Officers Report

Tel:
Case Officer: Christopher Lamb
Email: CLamb@hillingdon.gov.uk
Date: 5th January 2026
Our Ref: 15806/PRC/2025/169

RE: Erection of a single storey rear and two storey side extension, loft conversion including rear dormer, replacement garage outbuilding following demolition of existing, and new boundary walls

SITE: 1 ALMOND AVENUE ICKENHAM

DRAWING NO.	REVISION
A100	P1

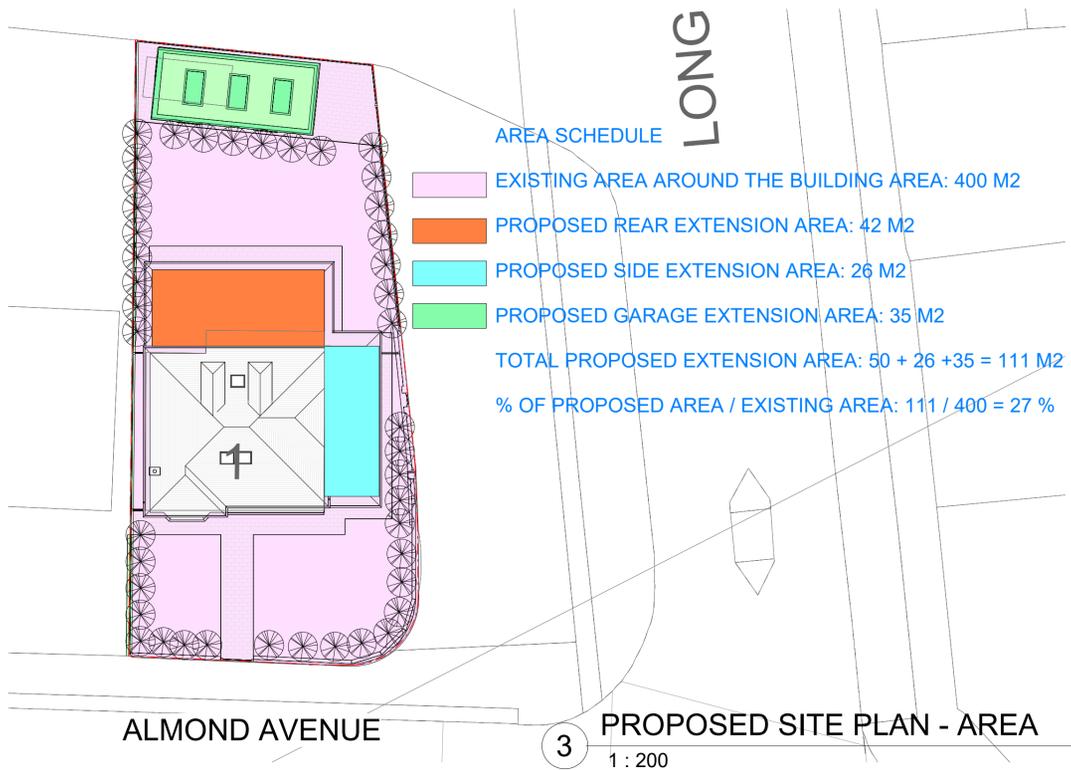
Boundary treatments for properties facing onto Almond Avenue generally consist of open frontages with low feature brick walls, as currently exists at the site. The proposal seeks to introduce a higher brick wall with horizontal metal bars, with a maximum height of 1.85m. It is considered that such a boundary wall would harmfully enclose the site and appear at odds with the open frontages that are characteristic of the street scene and Conservation Area more generally. This visual harm would be exacerbated by the corner plot location of the site, with properties along Long Lane also characterised by open frontages. Give the above, this aspect should therefore be removed from any future planning application.

The proposed outbuilding would be of a similar height to the existing structure, however significantly larger in footprint. Indeed, the proposed width, at 10.1m, would notably exceed the width of the existing dwelling (9.9m). As such, the building would fail to appear as appropriately subservient, and should therefore be reduced in overall width. Should a reduction in the width additionally allow for more of the rear boundary hedgerow to be retained, this would also be favourable, as discussed further below. A condition is likely to be included on any permission to ensure the outbuilding is used solely for purposes incidental to the enjoyment of the dwelling and cannot be occupied independently.

- Revisions to the proposed rear extension, roof alterations and outbuilding in accordance with the advice given above.
- Removal of the proposed boundary treatments. A low brick wall or replacement wall similar to the existing, retaining an open frontage, would be acceptable.
- Additional landscaping measures
